Our Ref: FP/43/18/HH

Development Front garage extension

Location 3 Outerwyke Avenue Felpham,,

DRAWING	SCALE
PLANNING	1/100
DATE: JANUARY 2018	
DRAWN: T. Murray	
DRAWING: 18/05/2	REVISION:

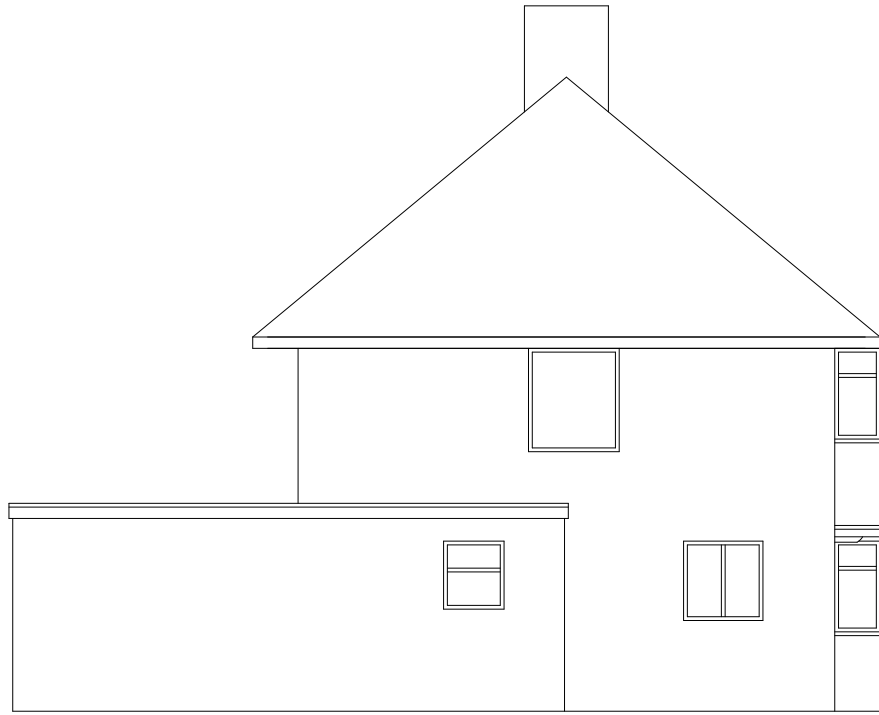
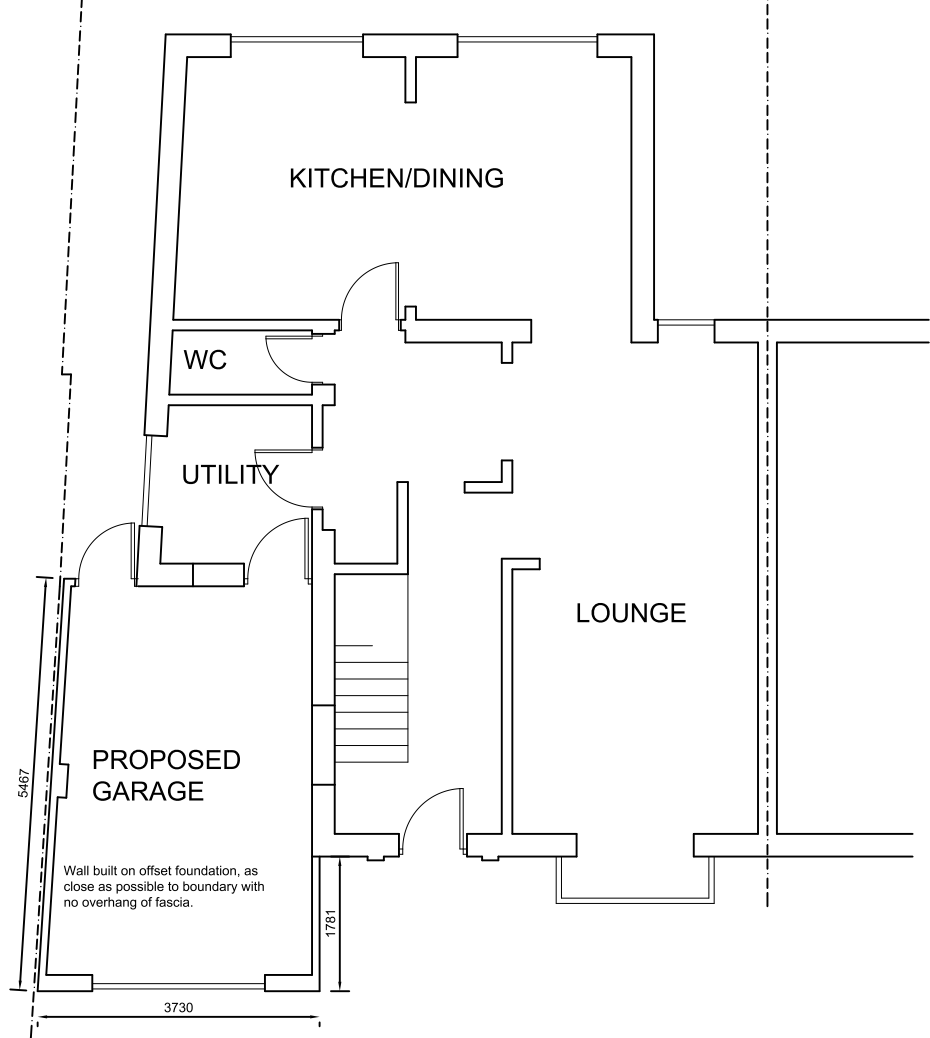
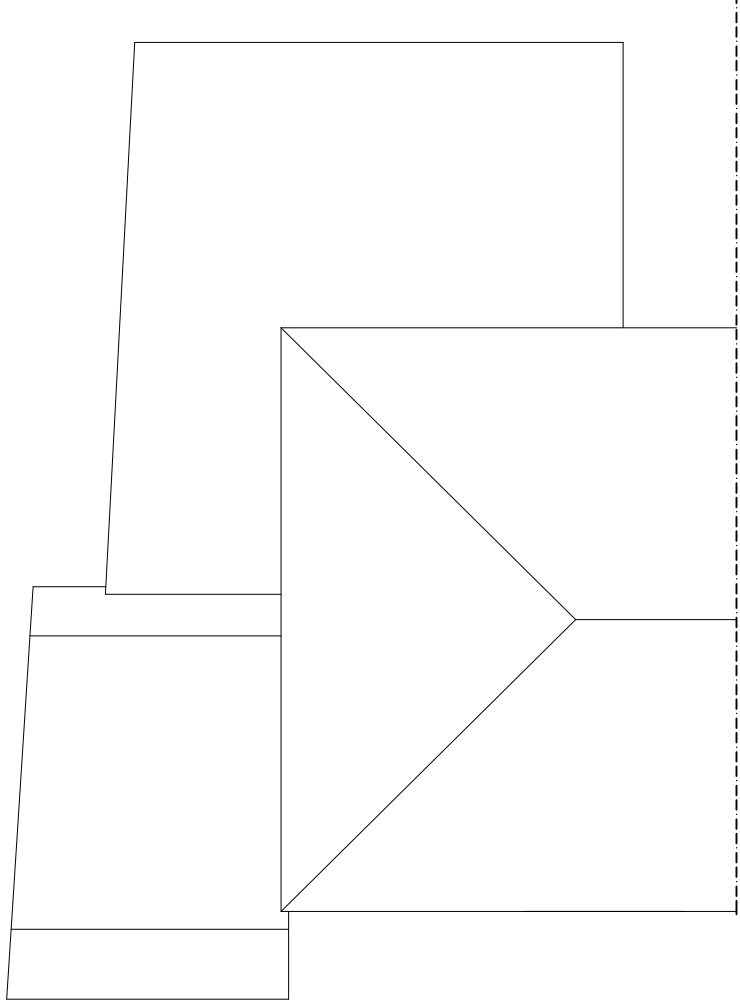
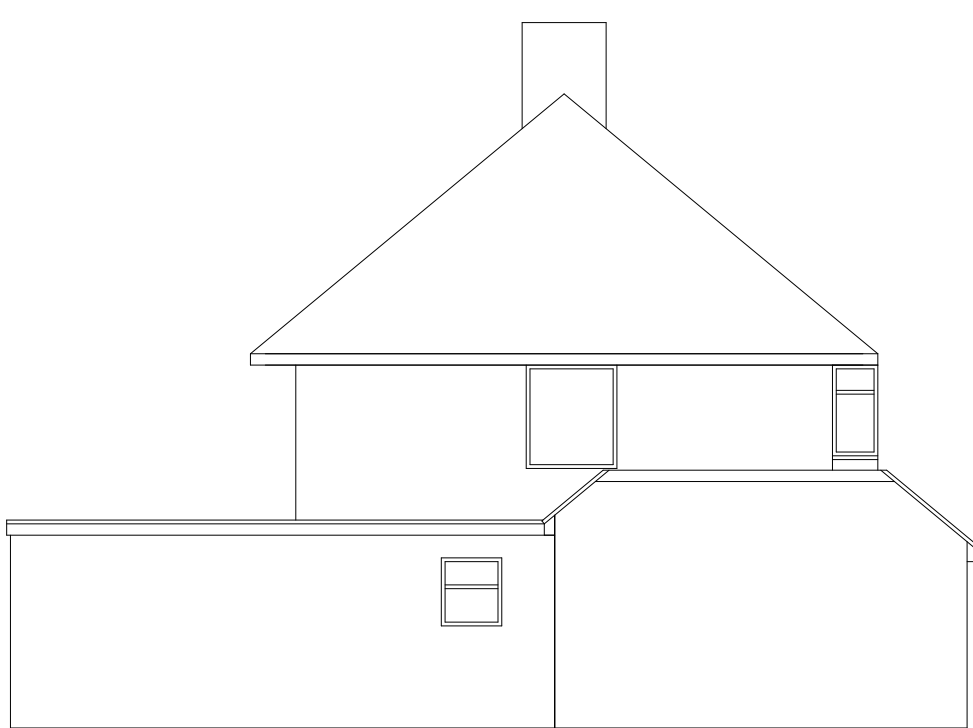
The utility window on the floor & elevation do not measure accordingly. Please forward amended plans.
